Current Zoning: R-3 (single family residential)
Proposed Zoning: O-1(CD) (office, conditional)

Approximately 7.07 acres located at the intersection of Zoar Road and Thomas Road, south of Youngblood Road.

The petition proposes to reuse the existing structures on the site to allow for office, research, educational, and dormitory uses for the F.A. Bartlett Tree Expert Company.

RZ1.0

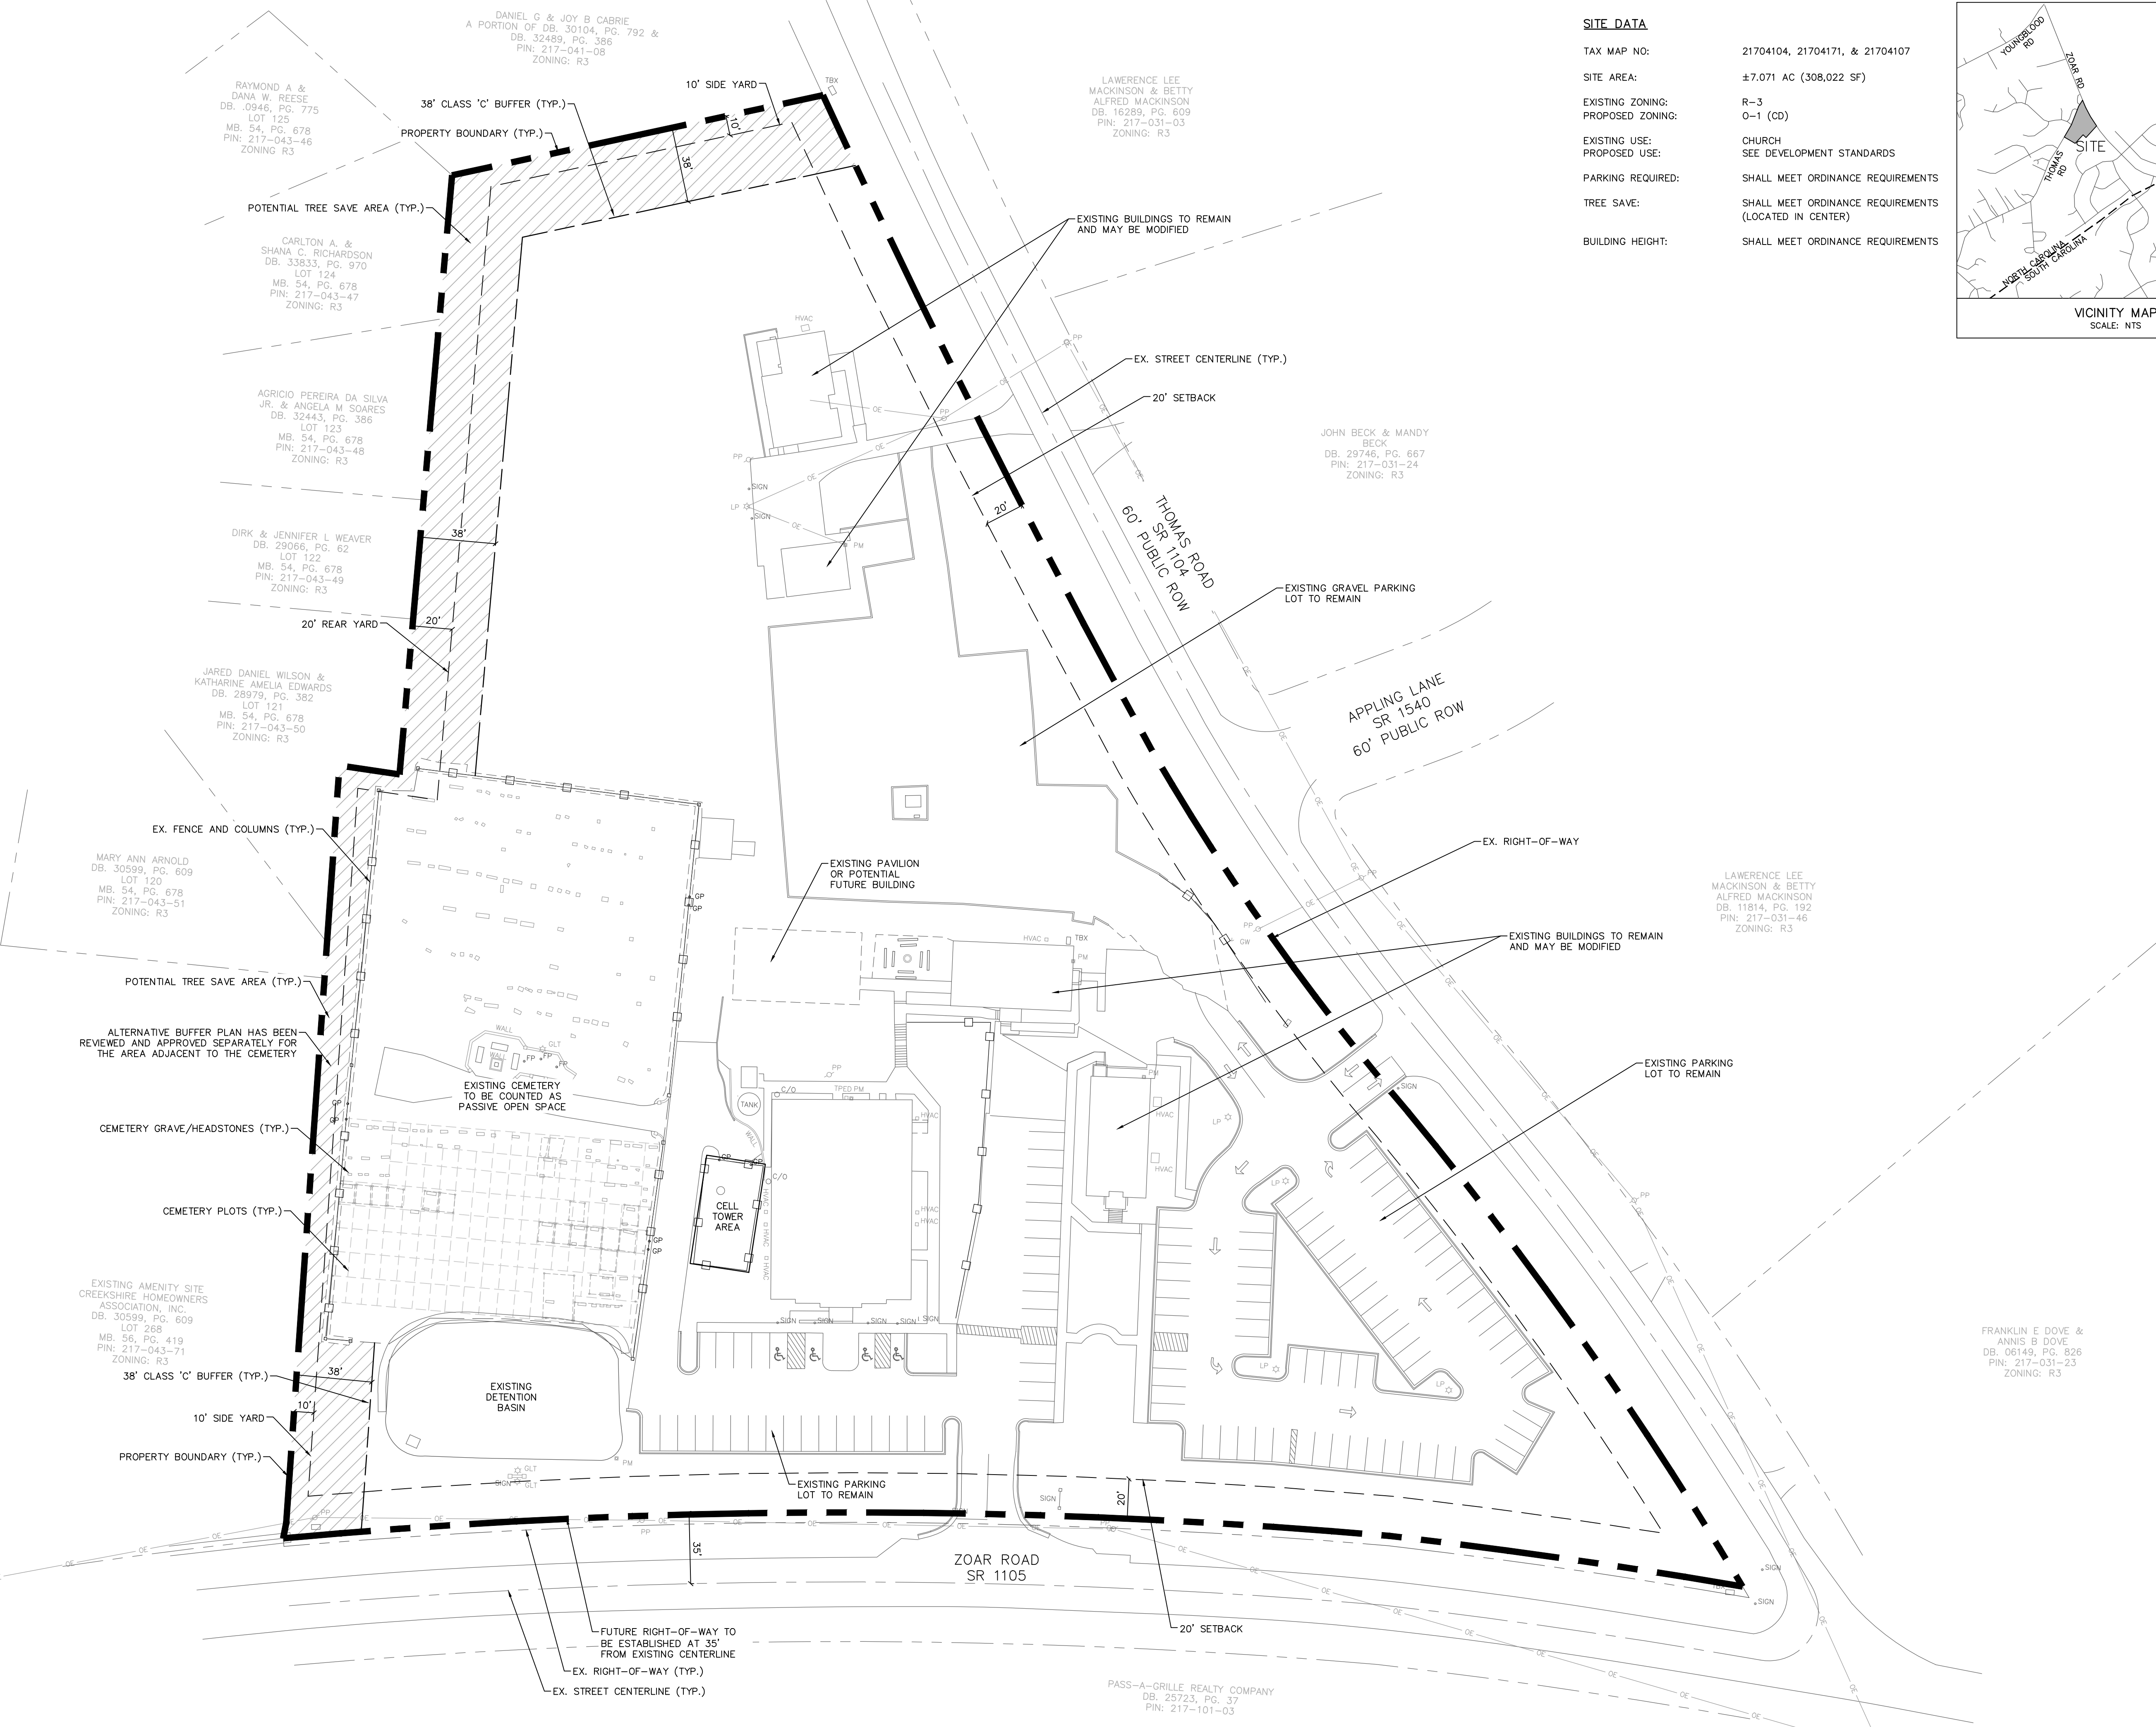
1. Dimension the future back of curb from the centerline on both Zoar Road and Thomas Road.
2. Revise conditional notes to commit to dedicate 35.5 feet of right-of-way from the road centerline on Zoar Road.

3. Revise the site plan and notes to commit to extend the sidewalk on Zoar Road across the site's frontage.
4. Add conditional note specifying "the Petitioner shall dedicate and convey in fee simple all rights-of-way to the City before the site's first building certificate of occupancy is issued. CDOT requests rights-of-way set at 2' behind back of sidewalk where feasible."

6. If the site is to remain in the ETJ: Revise site plan and conditional note(s) to construct 8-foot planting strips and 12-foot sidewalks on Zoar Road and 8-foot planting strips and 6-foot sidewalks on Thomas Road.

9. Clarify in the conditional notes that a dwelling use would be accessory to the principal use and labelled as a dormitory.
